**Consultation Response from Mike Hibbert,  
KC Waste Strategy( Refuse & Recycling)**

**2022/92842 The Carlton Nursing Home, 25, Greenway, Milnsbridge, Huddersfield, HD3 4RZ**

**Change of use and internal alterations to former nursing home (C2) to form 12 apartments (C3)**

**Responding Ref: WPS 22-50**

Proposed Site Layout 1.100

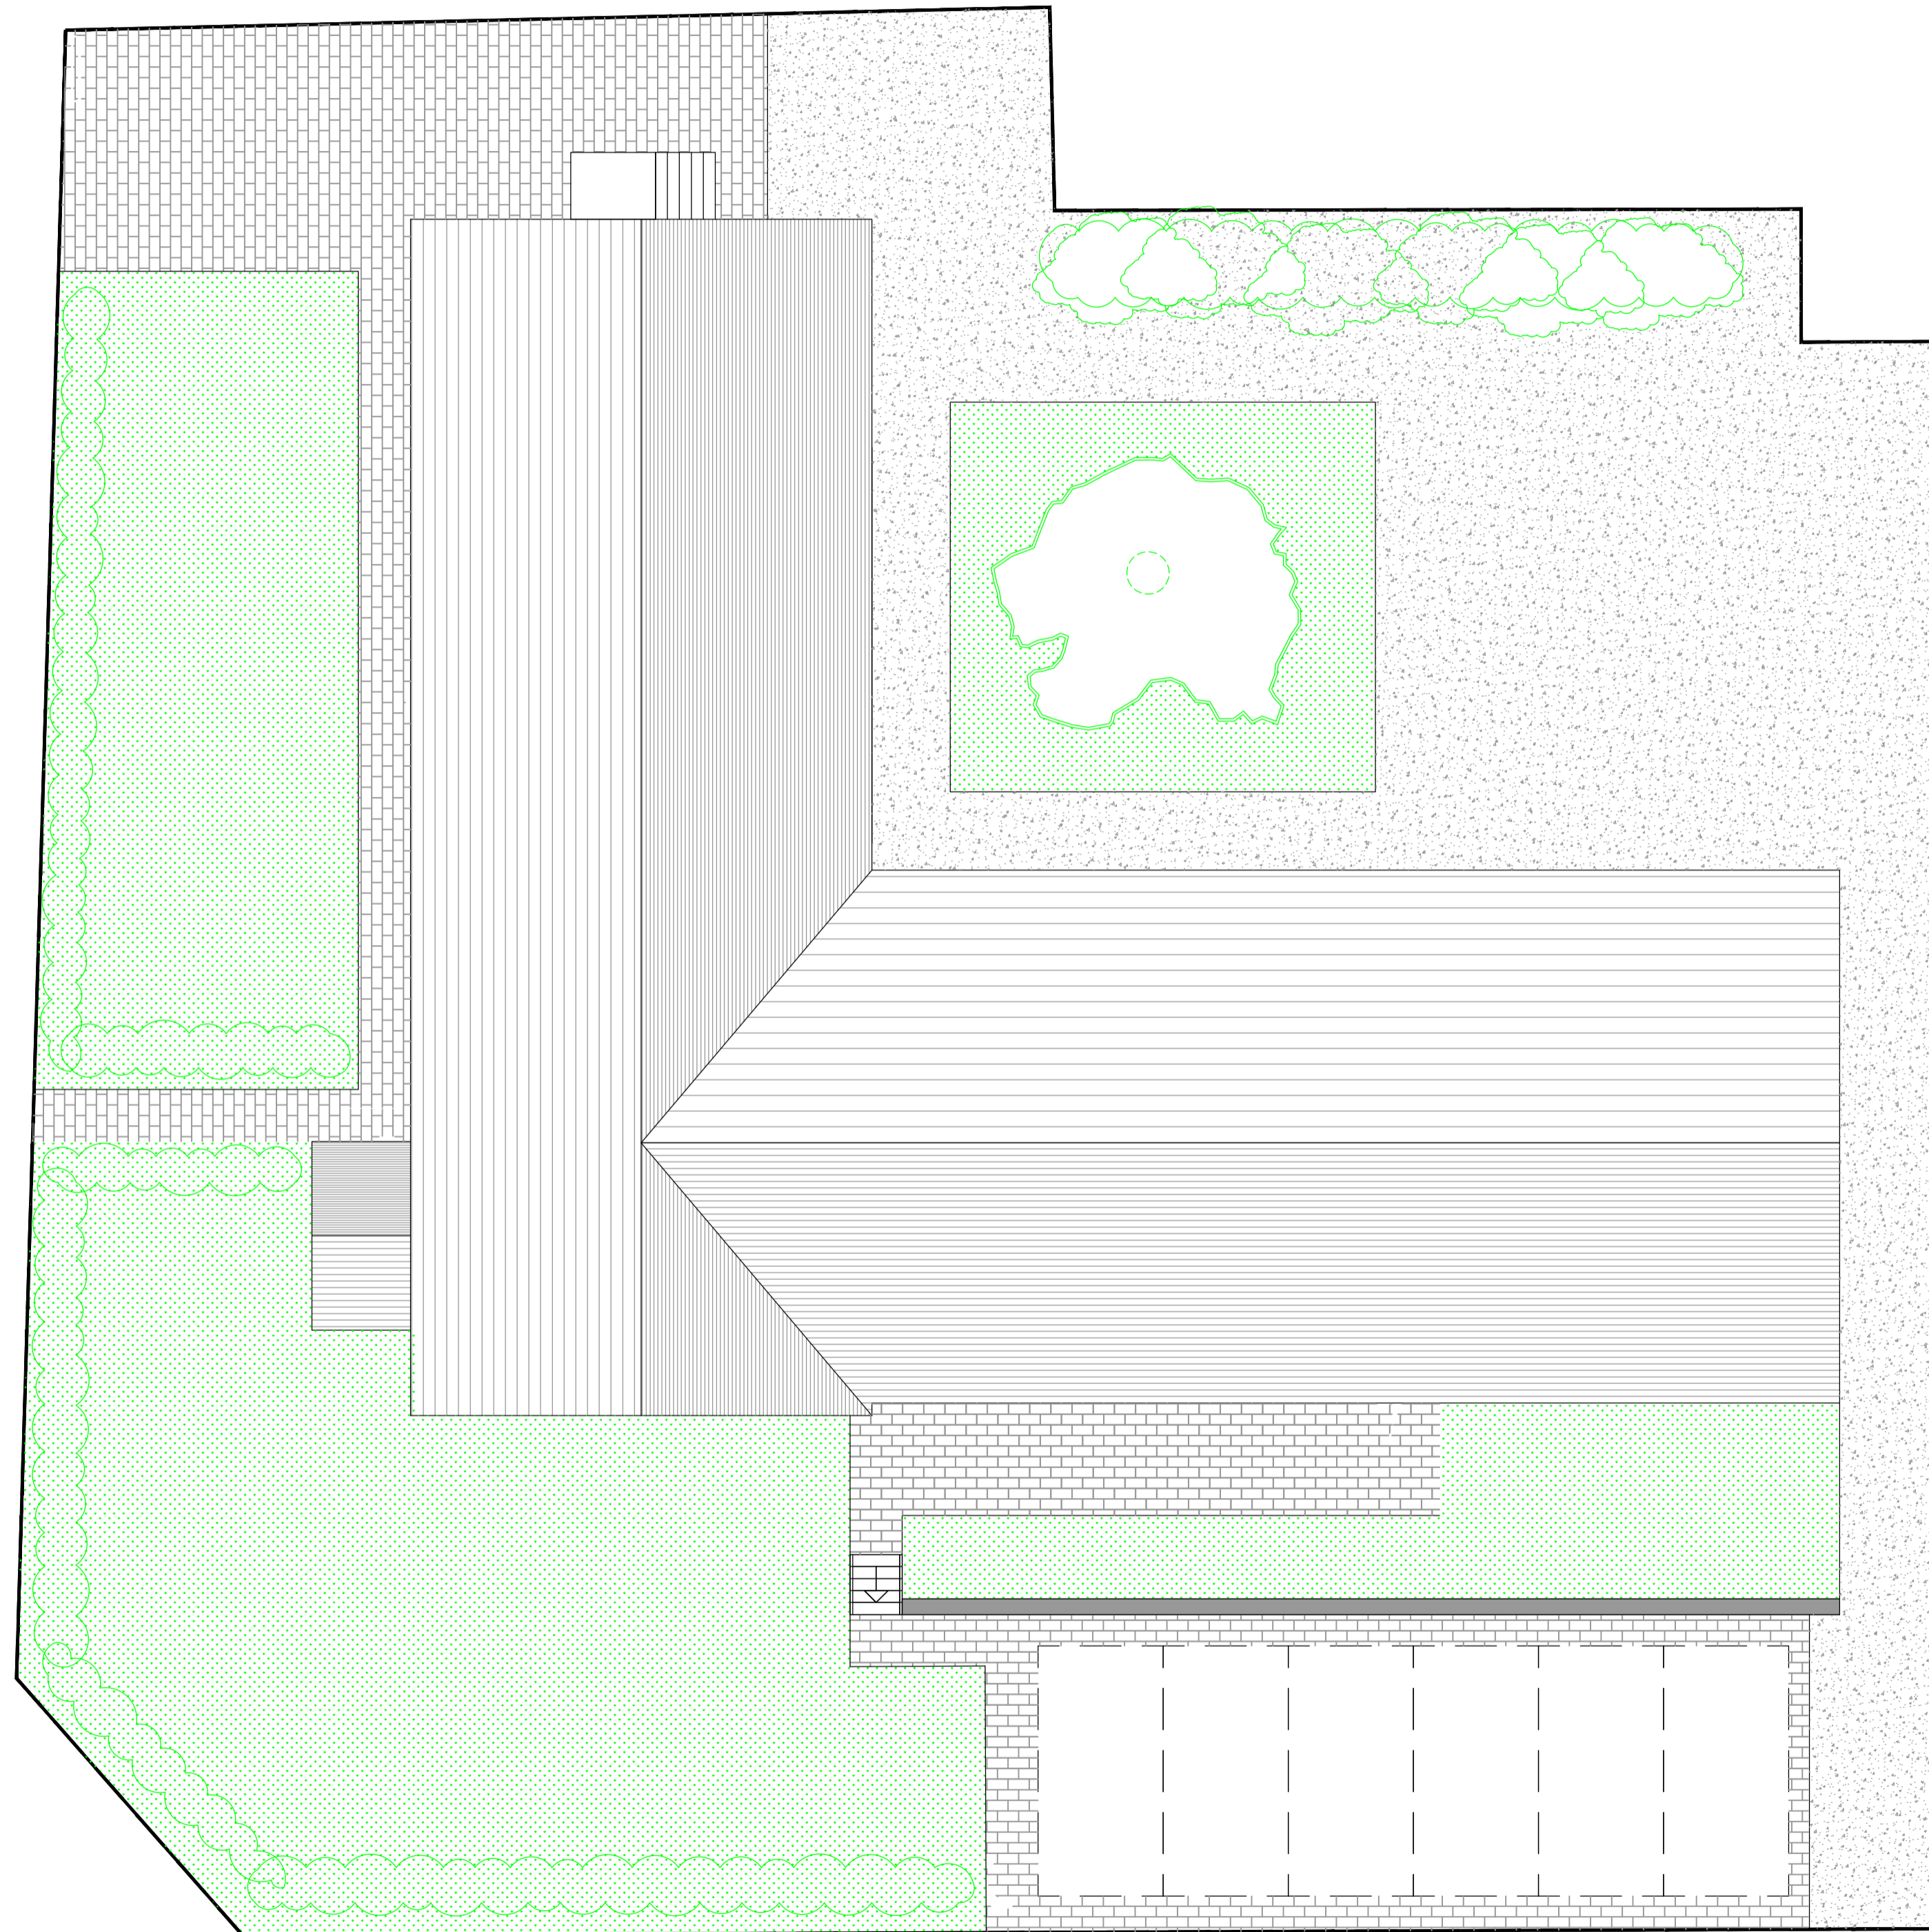
- The submitted Proposed Parking and Amenity plan ref 2206/03 dated August 2022 shows a bin storage location to at the eastern end of the building.
- For 12 apartments the recommended waste storage provision is 2160 ltrs (12X180 litres) for both residual and recycling bins. Separate 240 ltrs bins for individual apartments would not be practical. Appropriate waste storage provision would be 4 x 1100 ltrs wheeliebins. (2x Recycling and 2x residual).

- The walk distance from the Northern entrance points of the block to proposed bin store is approximately 20m whereas the distance from the Western entrance is approximately 40m that is more than the 30m specified in guidance BS5906:2005.

- It should be noted that the proposed bin storage at approximately 3m is within recommended safe standoff distance of 6m from the building. There are windows and an access door to an apartment in the eastern gable end elevation. Storage should address the fire risk issues presented by large quantities of waste – it must be either 6m away from the building or be constructed of suitable material to contain and prevent the spread of fire. See BS5906:2005, Building Regs 2010 Part H6 and CFPA-E Guideline No 7:2022 F.

- Guidance indicates the floor space for a 1100ltr wheelibins is 1575mmx1190mm with space to manoeuvre the bins within the store so the bin store dimensions would depend on configuration within the store. There is no details of the exact location or design of the bin store provided. Additional information is required detailing waste storage, containers, capacity and design of the waste storage compound including, screening, surfacing and security. Appropriate standards are detailed in the Kirklees Waste Management Design Guide 2020. Bin store surfaces should be durable and waterproof enough to withstand heavy duty cleaning such as power washing.

- The bin storage area and access routes to the Bin Collection Point (BCP) should be constructed to withstand point loading and movement, impacts of larger bins over time, and to resist future rutting, pitting, cracking or other such surface degradation that would impair bin manoeuvring. To facilitate loading of full wheeliebins the surface between the bin store and BCP/ highway should be smooth hard surface without kerbs. The proposed layout must ensure that parked cars do not obstruct the route between the bin store and loading point.

- There will need to be installation of a dropped kerb on the route between the bin store and RCV collection point on Greenway.
